Application for a Non-Material Amendment Following a Grant of Planning Permission

Erection of 30 Dwellings

2019/62/91657

Amendments to plots 8,12-15, 23, 26, 29 & 30. Please see 1902-HT-03 NMA House Type Booklet.

HOUSE TYPE B
1902-HT-B-01B
STATION ROAD, SKELMANTHORPE
YORKSHIRE COUNTRY PROPERTIES
SCALE:1:100@A3 - MAY 2019
PARKER PEEL
ARCHITECTURAL
e jp@parkerpeel.co.uk w www.parkerpeel.co.uk t01924 921 860

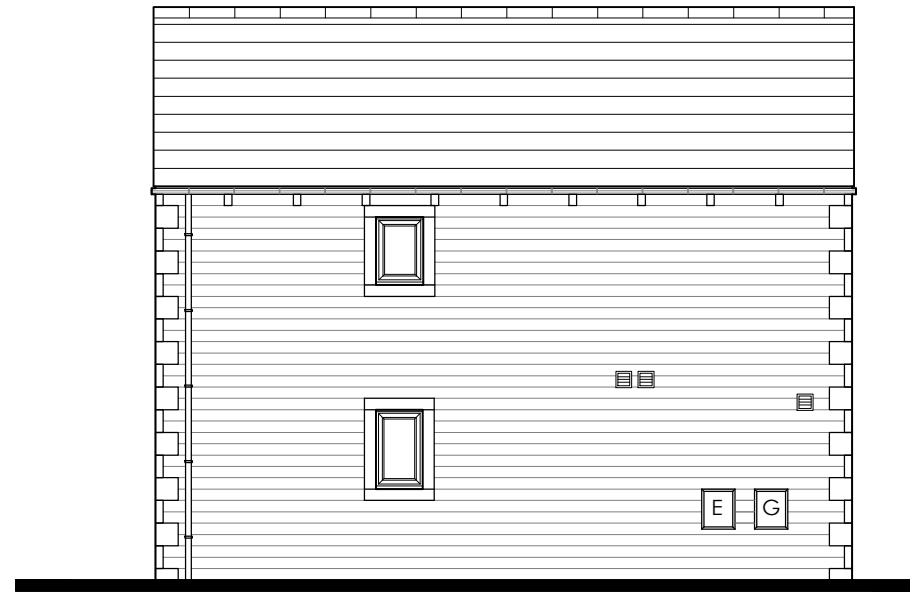
B Type (Plot 13-15) Side lights removed from French doors on rear elevation.
C1 Type (Plot 12) Additional side window added to bedroom 2.
C2 Type (Plot 8) Window added to Plot 8 bathroom only.
G Type (Plot 29) Single story rear extension added to provide additional kitchen space & utility room added.
J type (Plot 30) Rear window removed from bedroom 2.
K Type (Plot 25) Minor adjustments to overall build to suit construction purposes.
L Type (Plot 24) Parapet walls introduced at roof level.
M Type (Plot 23) Room above garage removed, other amendments including repositioned windows.
N Type (Plot 26) Side door to utility added & double window to the dining room replaced with a triple window.
